PLANNING AMENDMENT

APPLICANT NAME AND ADDRESS Miss R. Baker C/O JC Architectural Consultant Telephone:	AGENT NAME AND ADDRESS JC Architectural Consultant Rose Villa Main Road Holbeach Drove Spalding PE12 0PS Telephone: 07917358101
SITE ADDRESS DETAILS Former Telephone Exchange Common Road, Whaplode Drove, Spalding, PE12 0UF	
CURRENT APPLICATION NO: This amendment cannot be considered unless the relevant reference is stated.	H23-0201-26
Building Regulation reference relating to same development (if applicable)

Proposed Block Plan
Scale 1:100

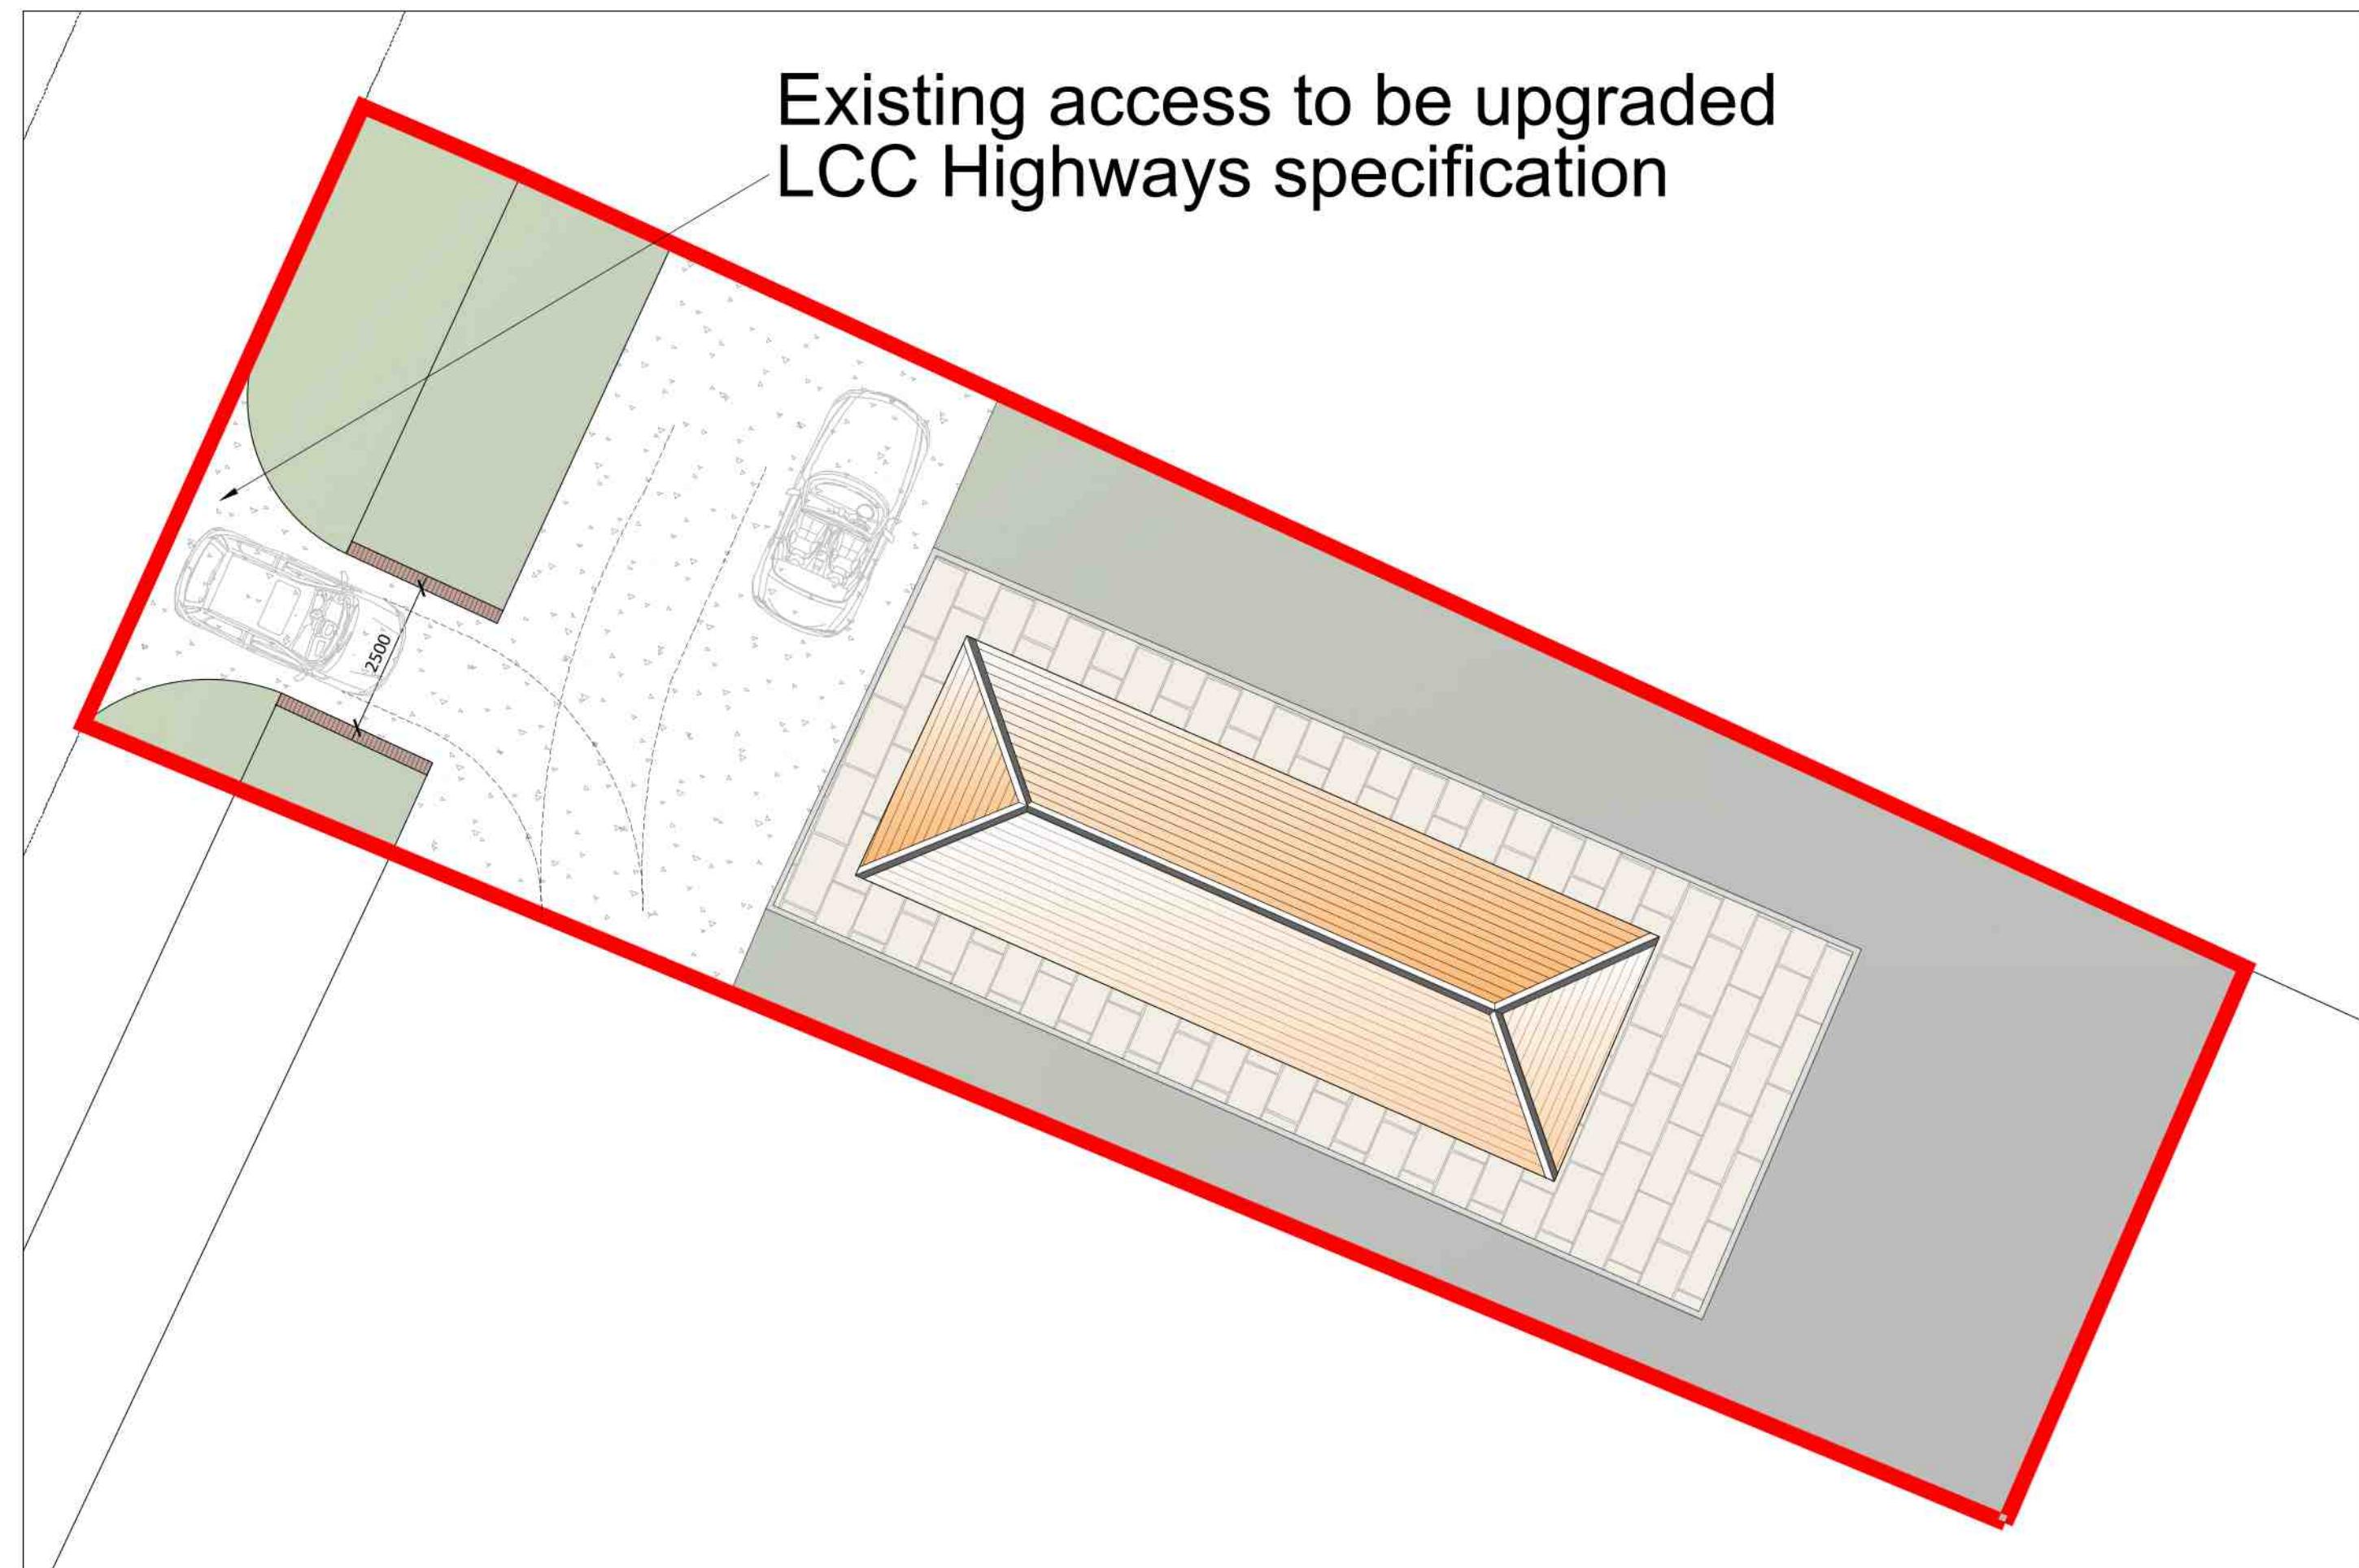
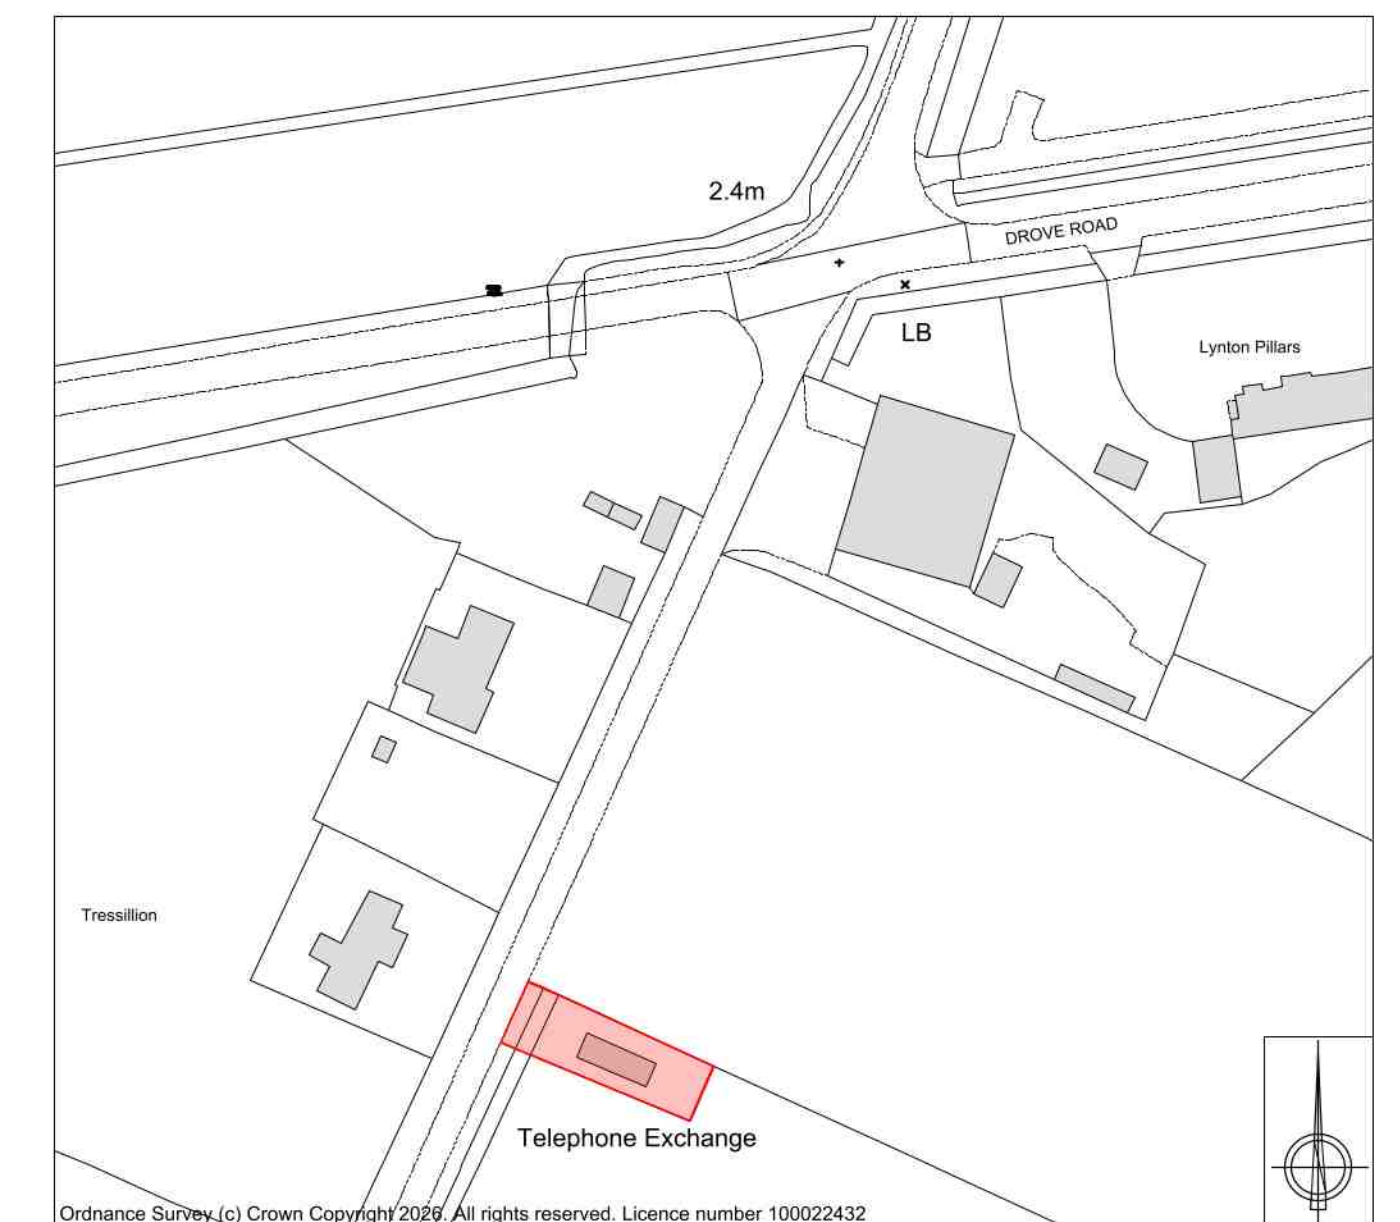
FULL DESCRIPTION OF DEVELOPMENT OF CURRENT APPLICATION THAT THIS AMENDMENT RELATES TO		
State details of amendments proposed. (Give a full detailed list of the changes, and also mark these clearly on the accompanying plans. Only the changes listed here will be considered)	Amended proposed block plan to show removal of garden structure and addition of Historical Significance Statement	
State drawing numbers of the current submission		
Has this amendment been requested by the Council? (If so, state Officer dealing with the application)	YES/NO	Yes – Jacob Bryan
Describe any part of the original development which is excluded by virtue of the amendment, and state any alteration to plot numbers	N/A	
Has a similar amendment been submitted under Building Regulations? (If so, state Building Control Surveyor dealing with application)	YES/NO	No
